From: Sarah Foreman 
Sent: 14 April 2019 18:47
To: Planning
Subject: planning application number BR/63/19/PL

Project:-	Proposed Residential Development 15-17 Kew Gardens Bognor Regis West Sussex		
Title:-	Proposed Floor Plans & Elevations (All Plots)		
Client:-	Farnden Developments Ltd		
Scale:-	1:50, 1:100 (@A1)		
Drawn By:-	PJD	Checked By:-	
Date:-	14/02/19	Date:-	
Job.No:-	180037	Drg.No:-	04

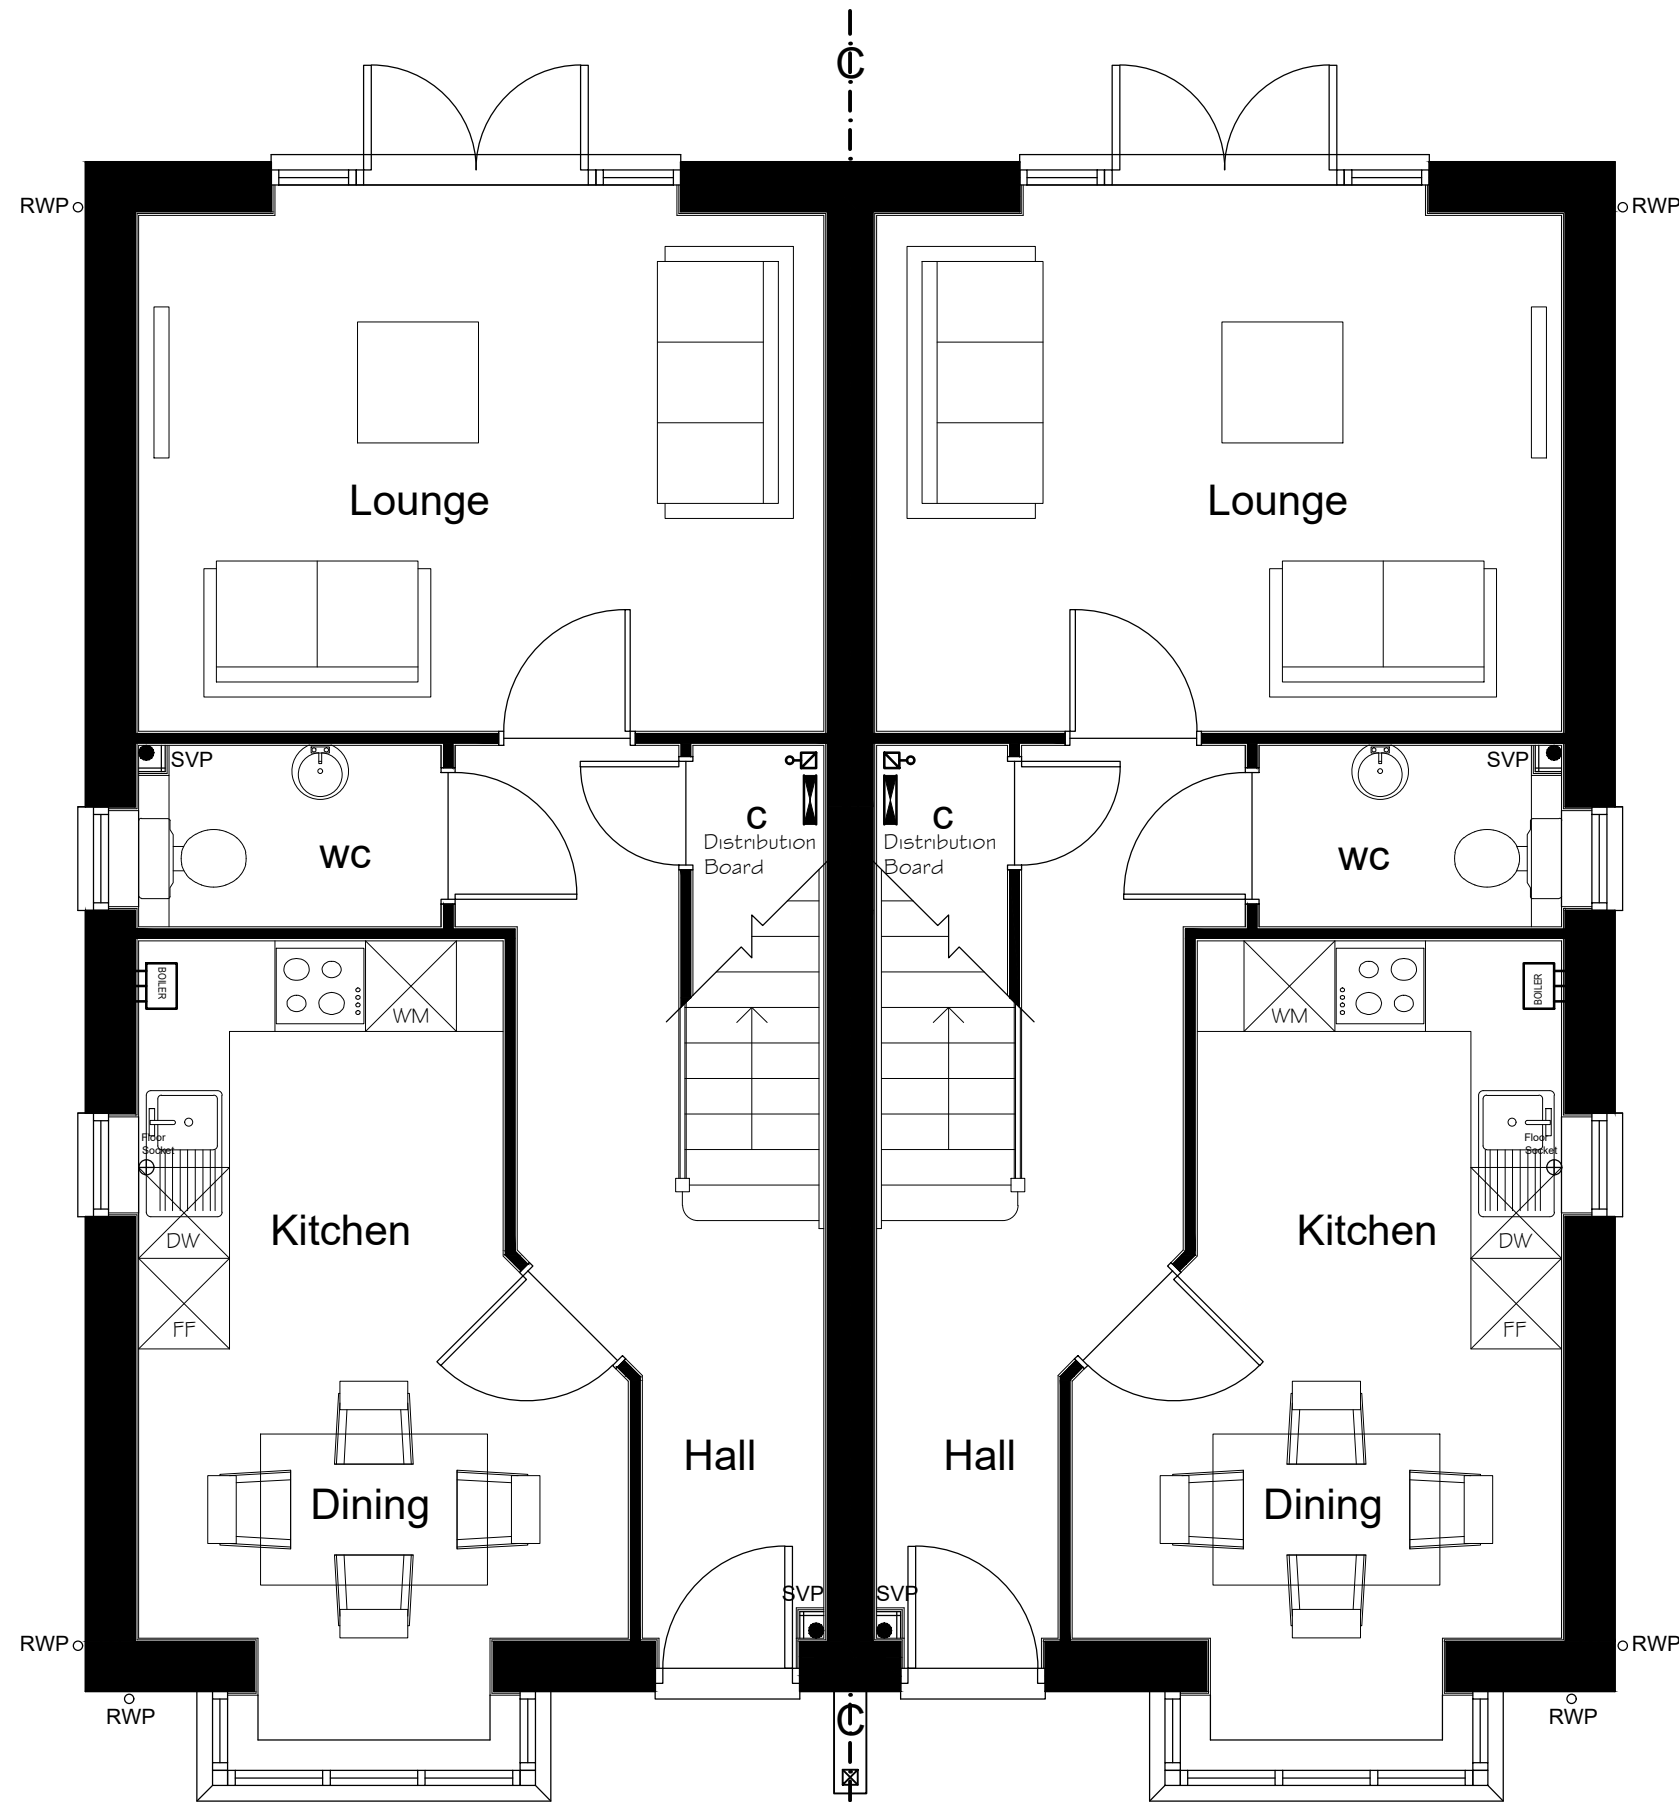
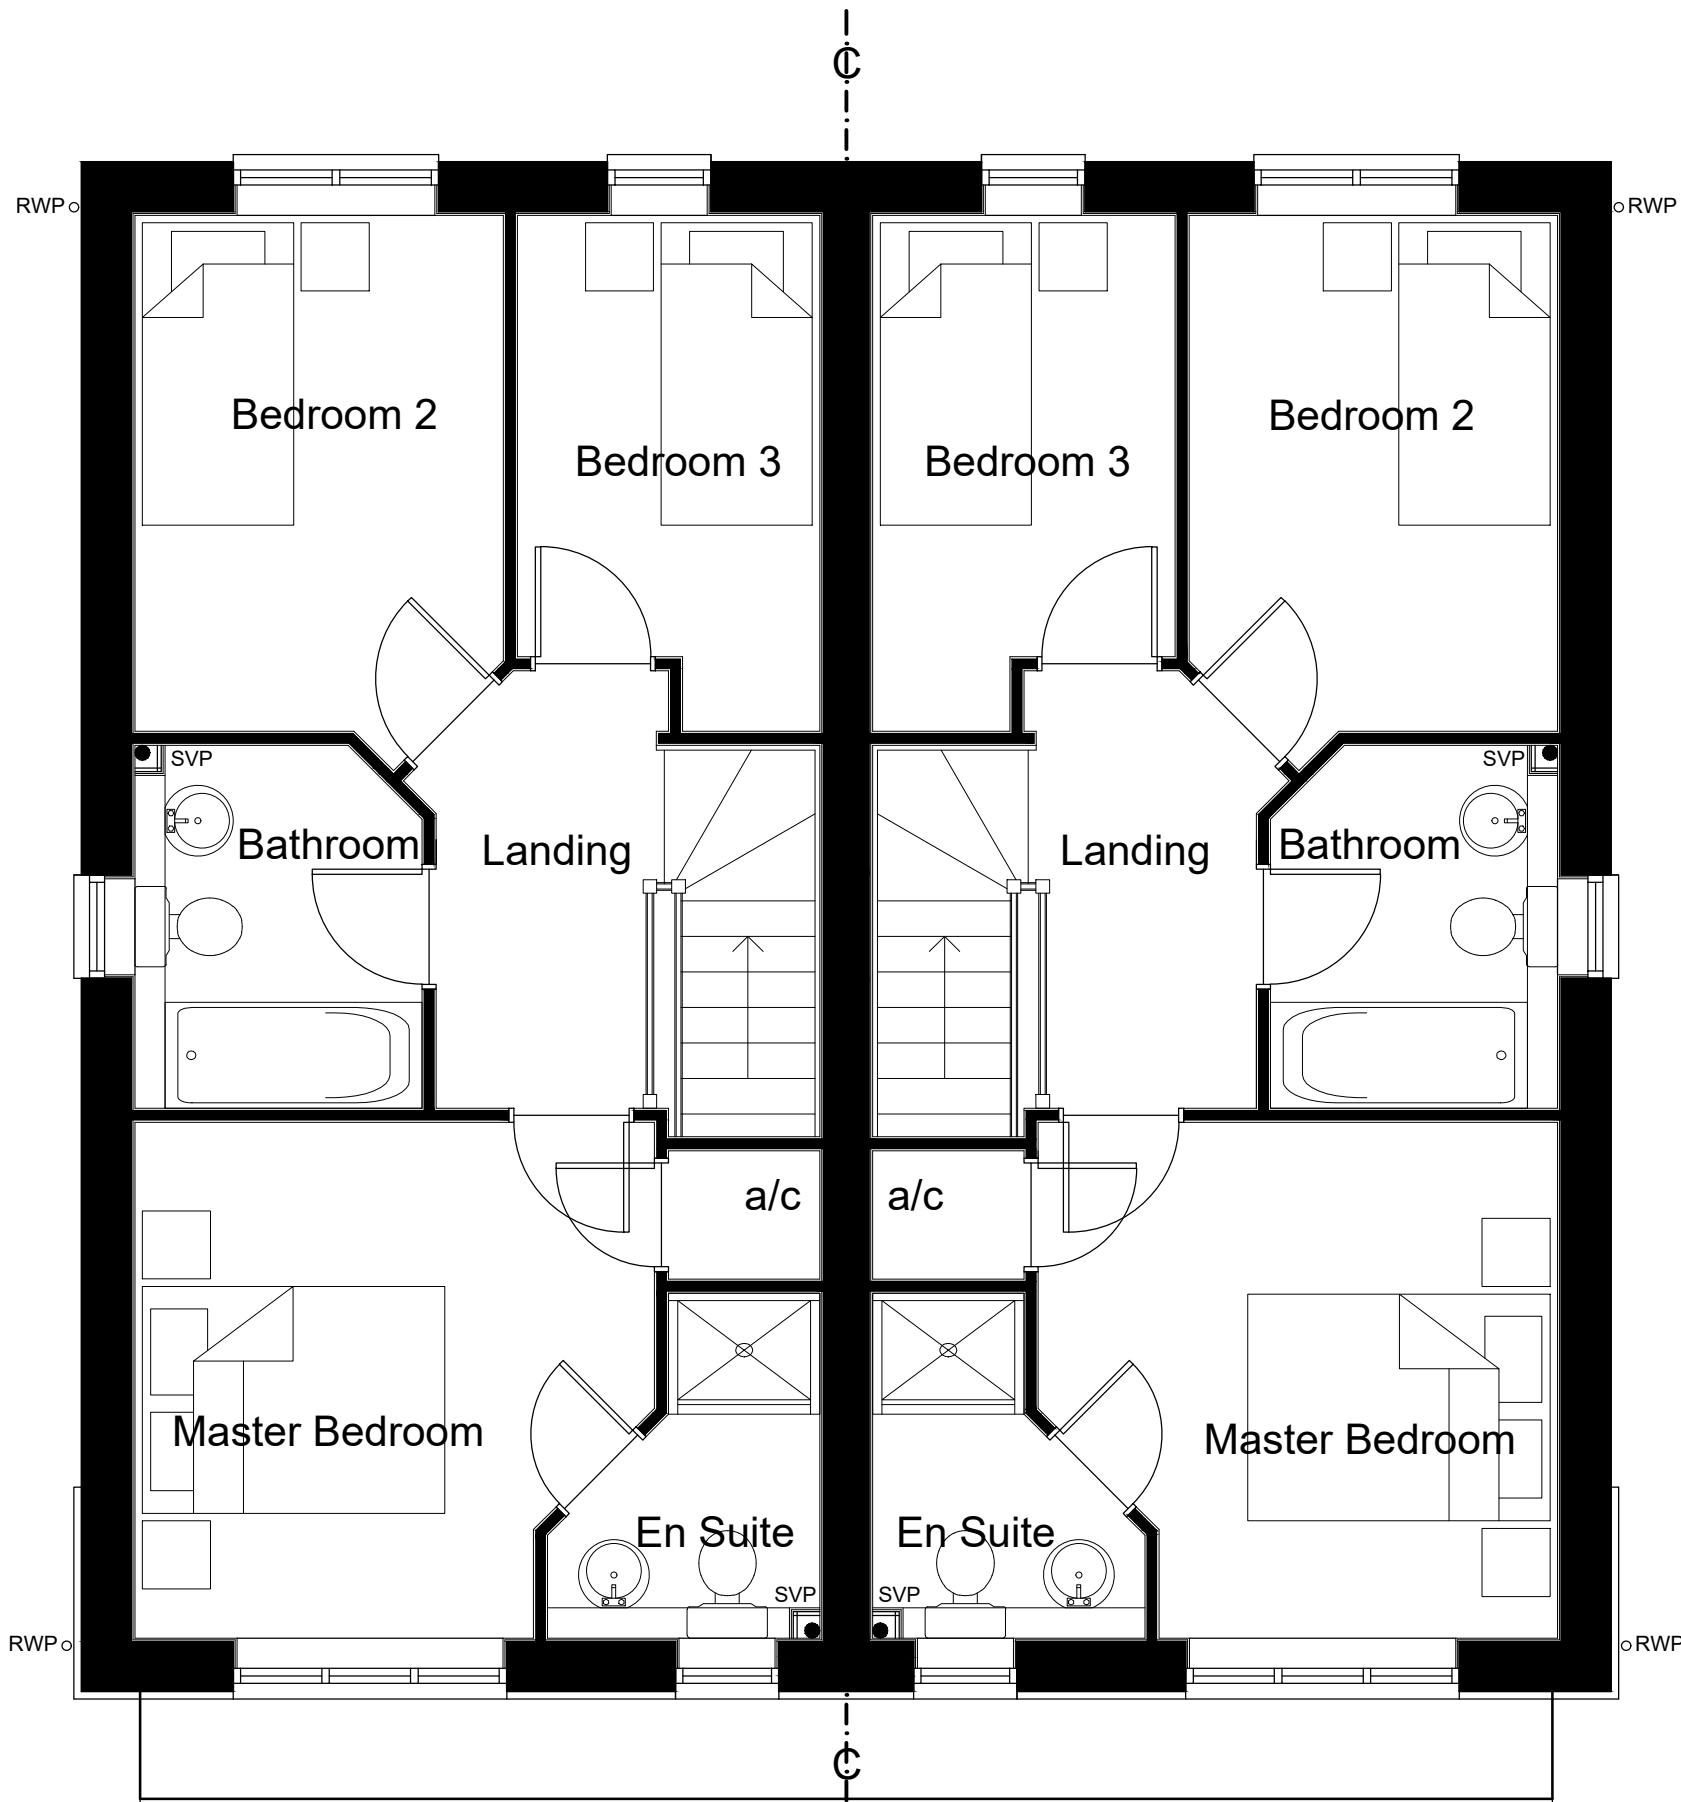
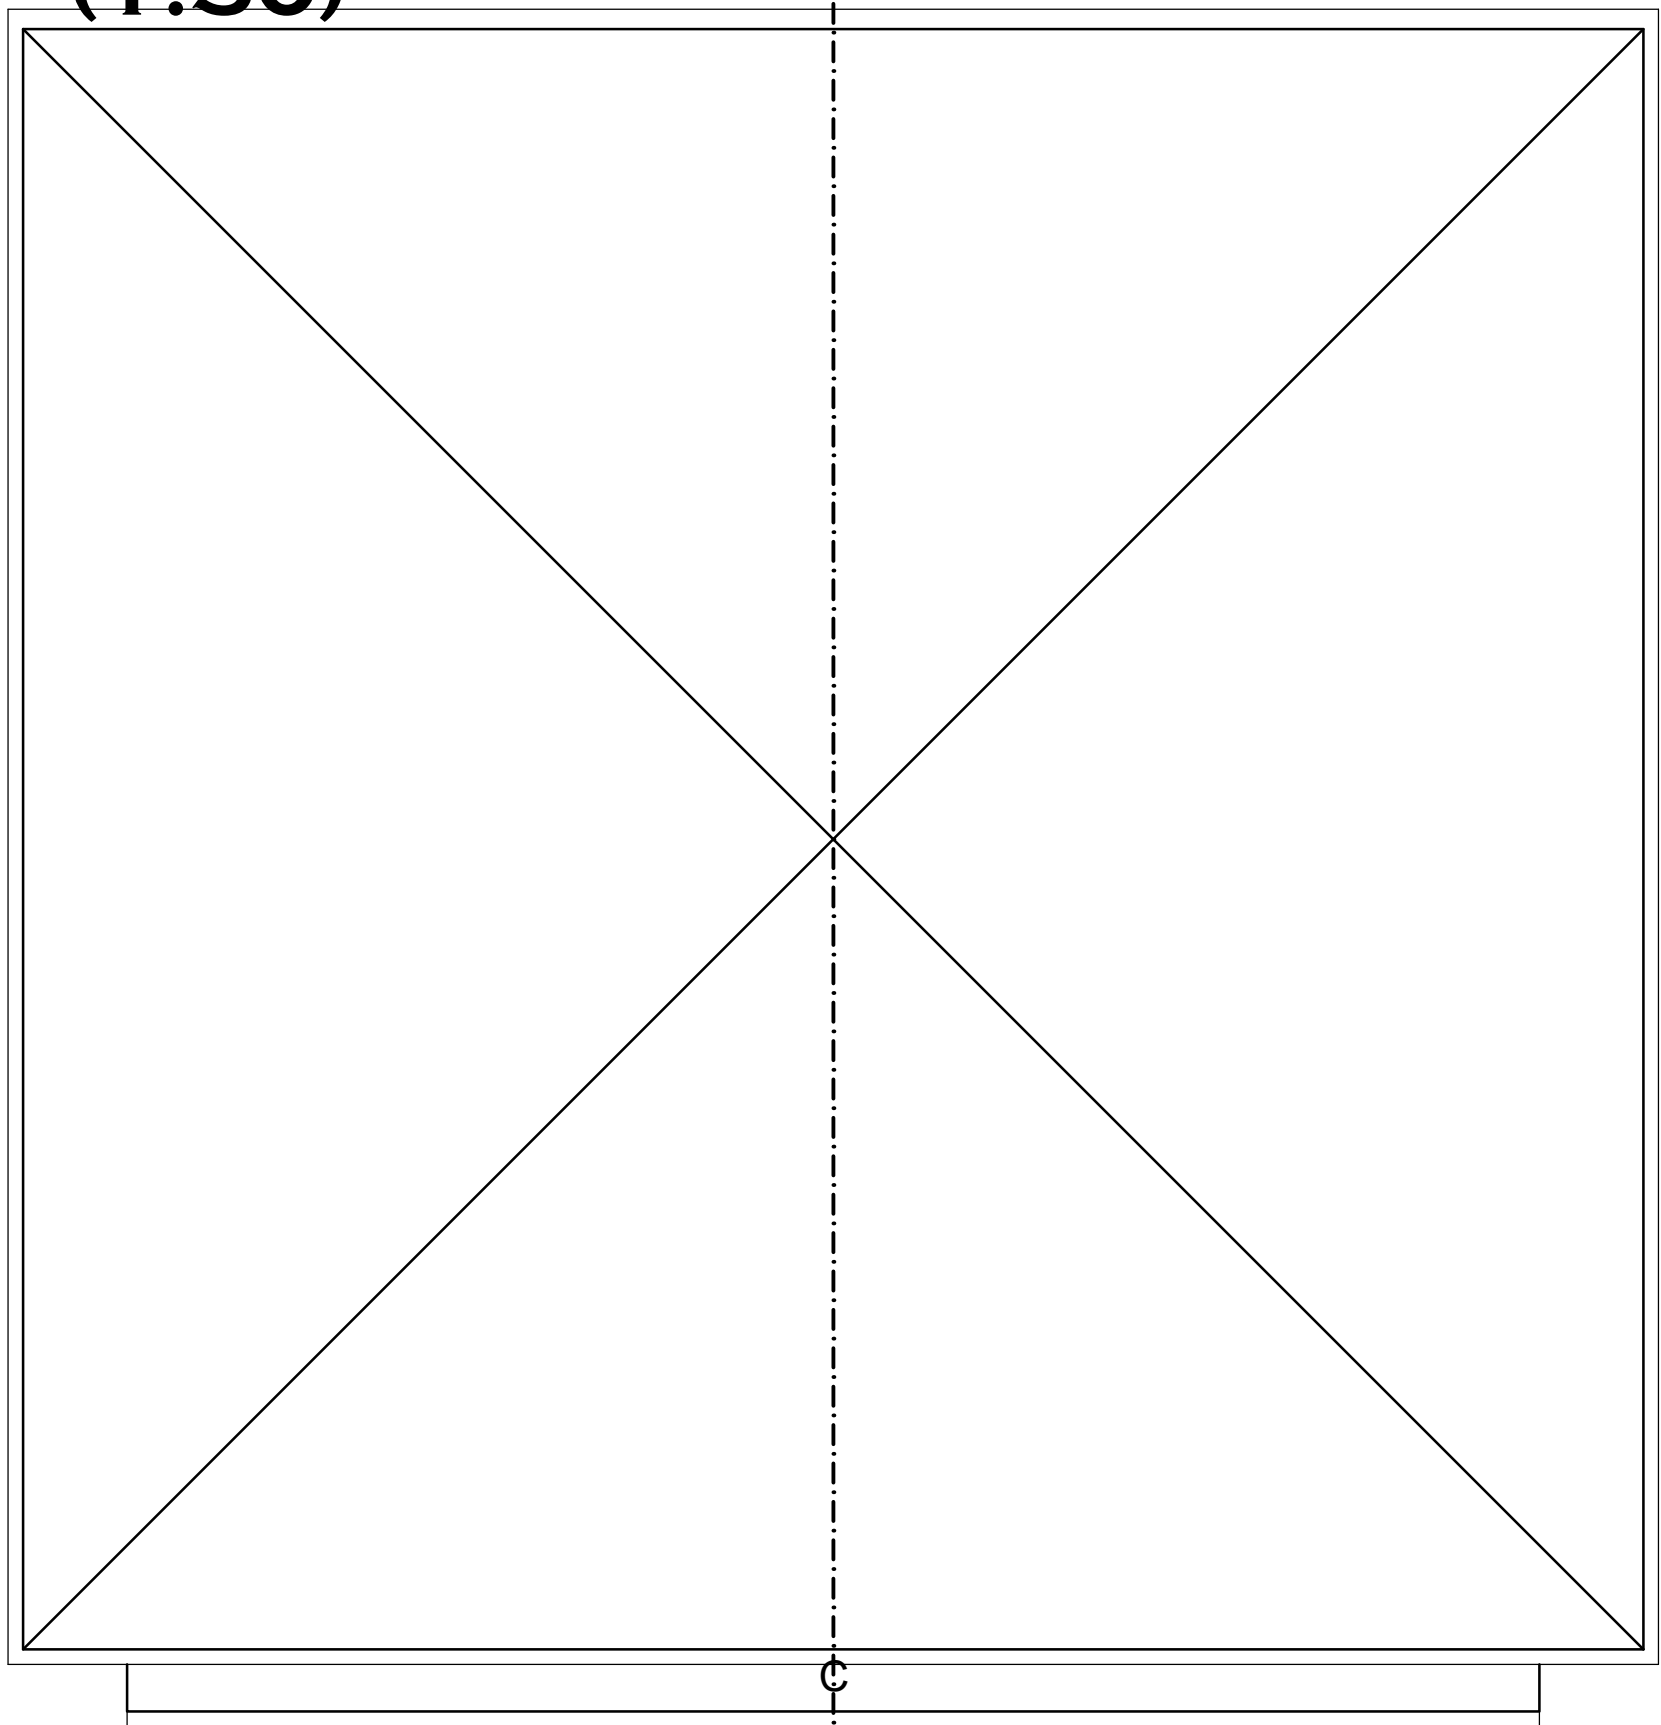
Also I object to the bay windows on the proposed build as they are not in keeping with the other properties in Kew Gardens.
